Recommendation Report for Planning Permission for Works or Extension to a Dwelling

REF NO: LU/260/21/HH

LOCATION: 49 Northway Road
Littlehampton
BN17 7JX

PROPOSAL: Erection of first floor rear extension

DRWG TITLE: **Proposed Elevations**
DRWG No: **1046_301**
REV: **B**

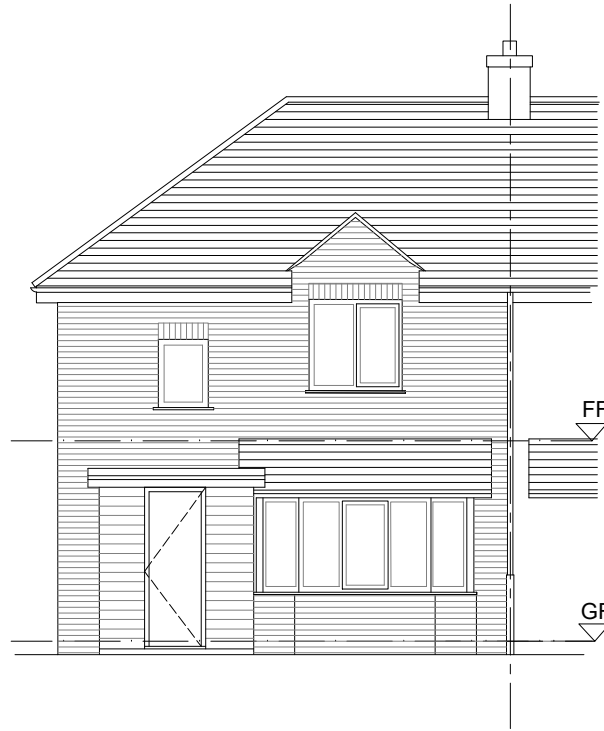
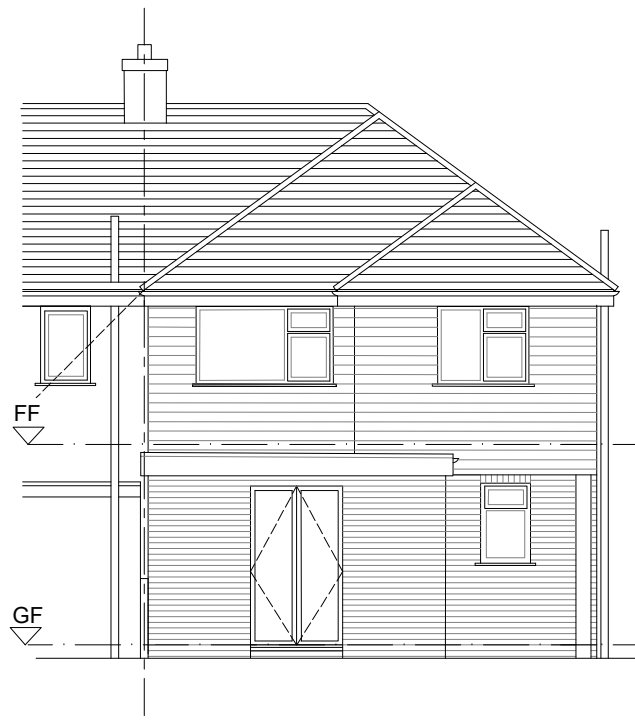
The extension will feature hipped roofs which extend in line with the existing roof. This has been altered from the previous application which sought a flat roof and the revision appears well integrated with the host dwelling.

Grey cladding is proposed to the external elevation of the extension and whilst the materials are not common in the street scene, with the cladding located to the rear of the dwelling and with views largely restricted, materials are considered acceptable.

The two storey addition will extend 3m in depth from the western elevation which will reduce in depth to 2m to the eastern elevation.

There is a first floor window to the neighbouring property at No.50. The extension does slightly intersect a 45 degree angle when drawn from the centre of the window. However this is very minor and with the extension having been reduced in depth to this elevation, it is not considered to result in significant harm by way of overbearing or overshadowing.

There will be 2 rear facing windows which replace existing albeit are located further north. These will have views over neighbouring gardens, although are not considered to provide views additional to that which are already achievable. 21m is retained to the rear boundary and with Northway Road running along the rear, views will not give rise to adverse overlooking.

DRWG TITLE: **Proposed site plan**
DRWG No: **1046_101**
REV: **B**

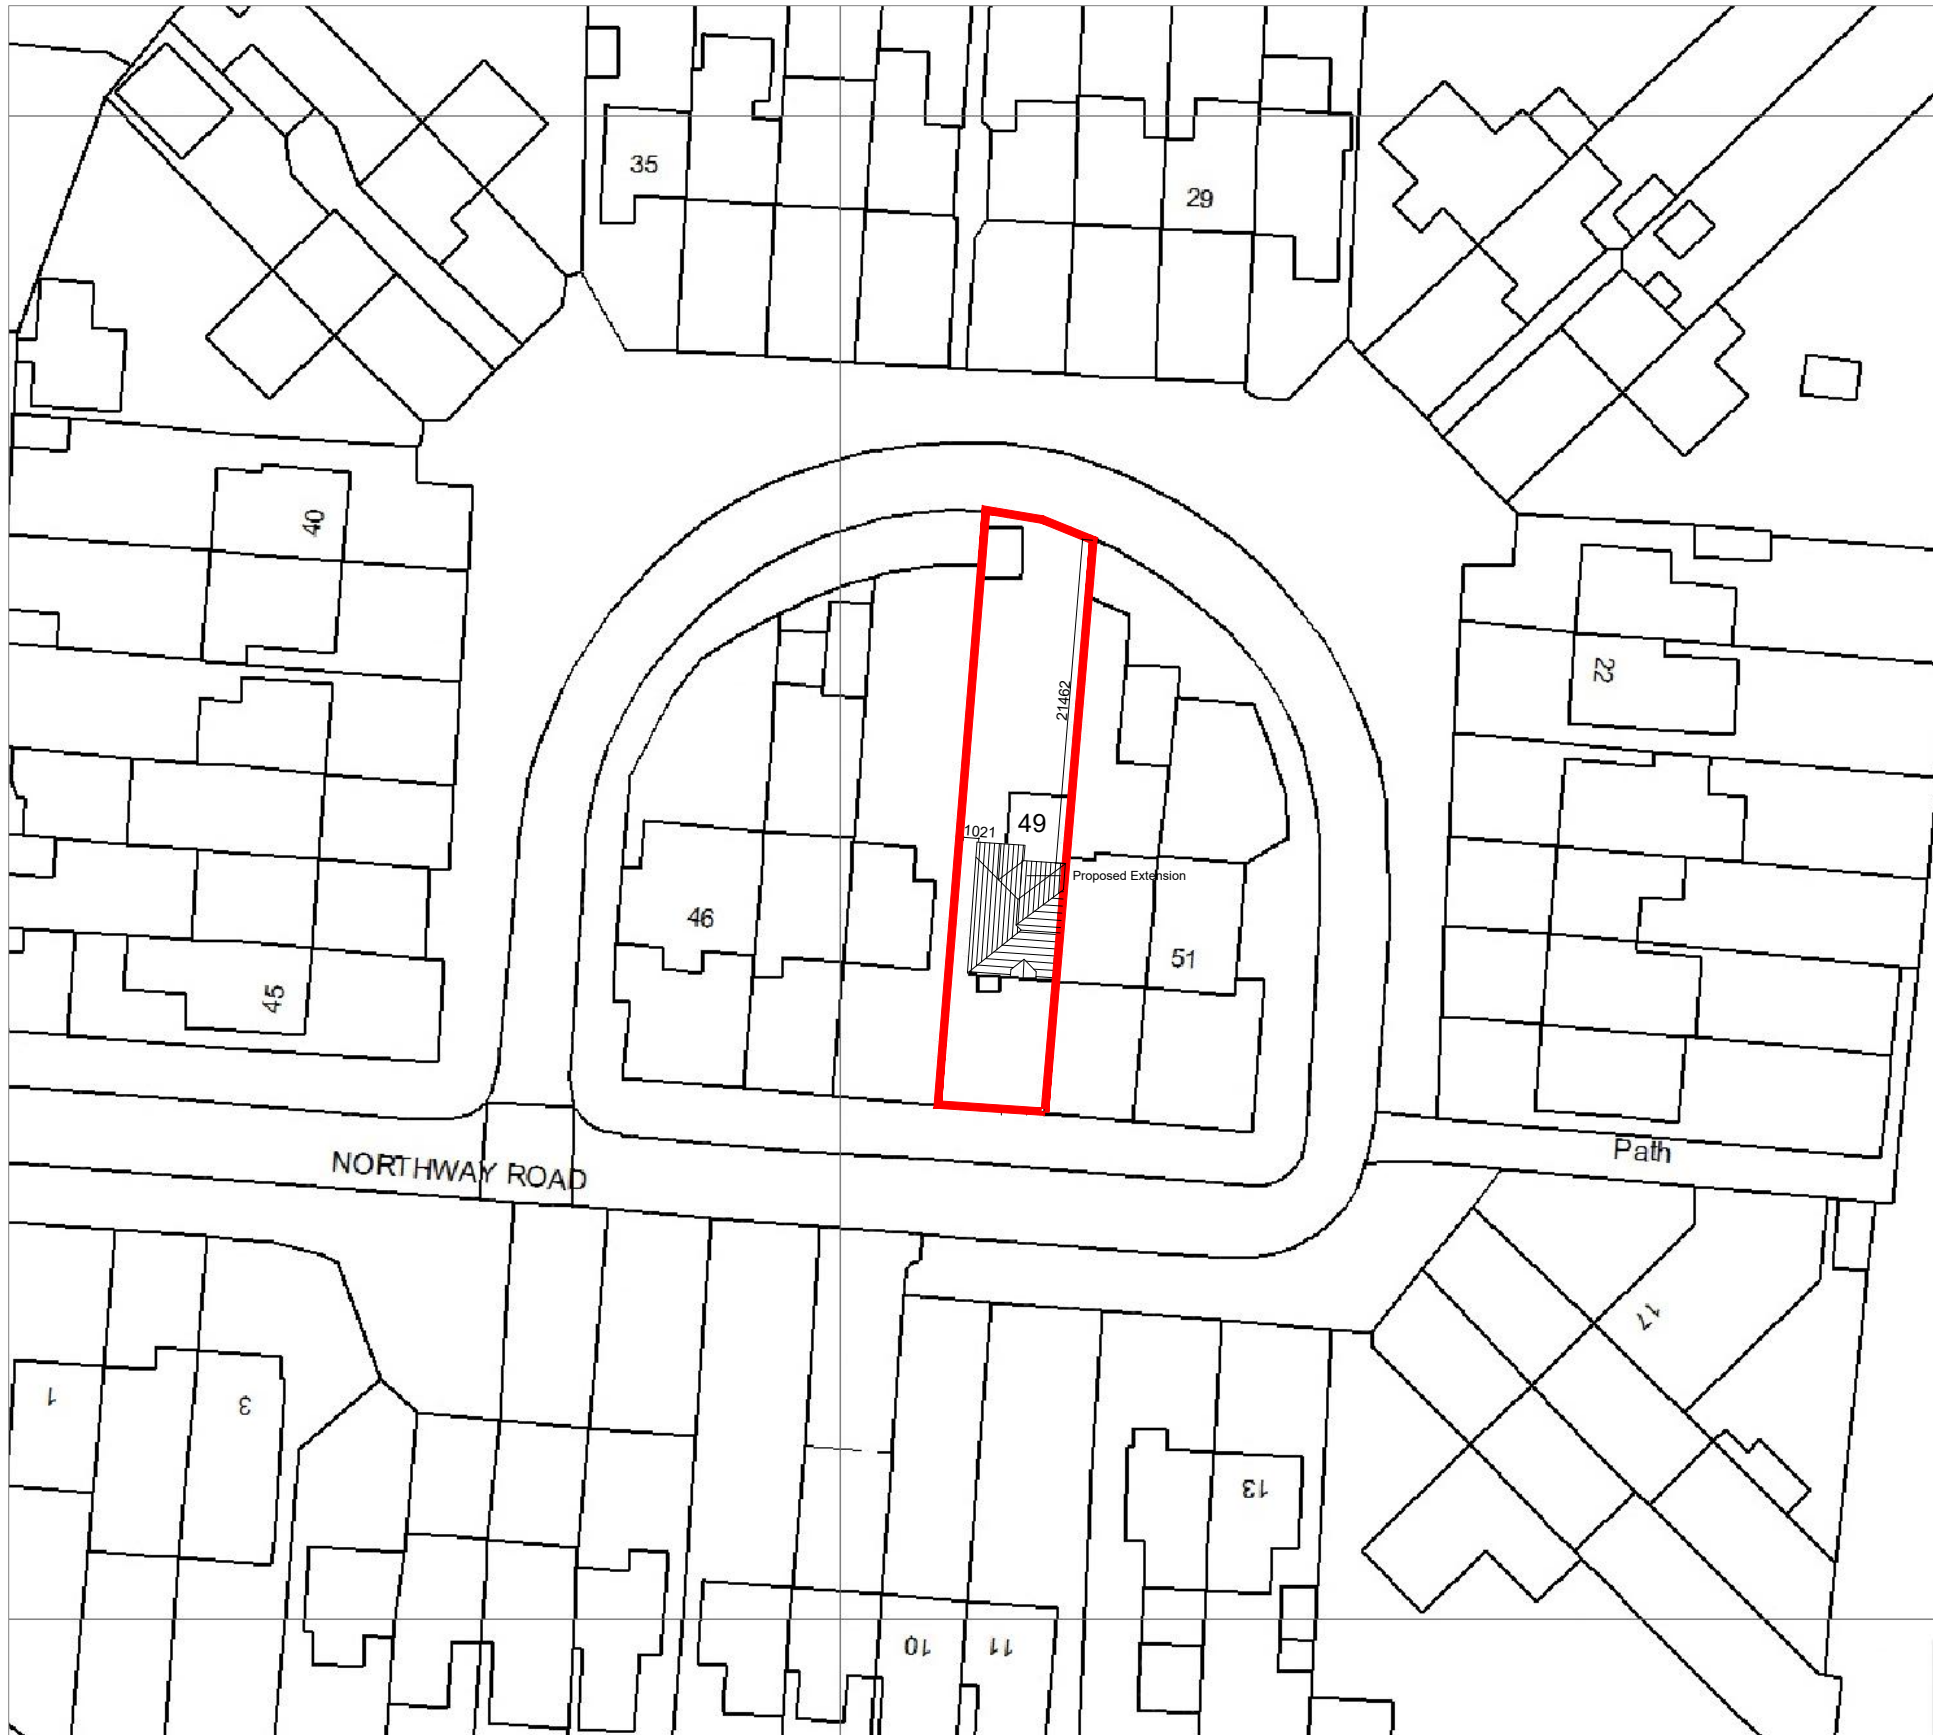
Due to the siting of the property to the west, with 1m retained to the boundary and a further 1m retained to the side elevation of the neighbouring dwelling, the extension is not considered to intersect a 45 degree angle and is not considered to result in adverse impacts.
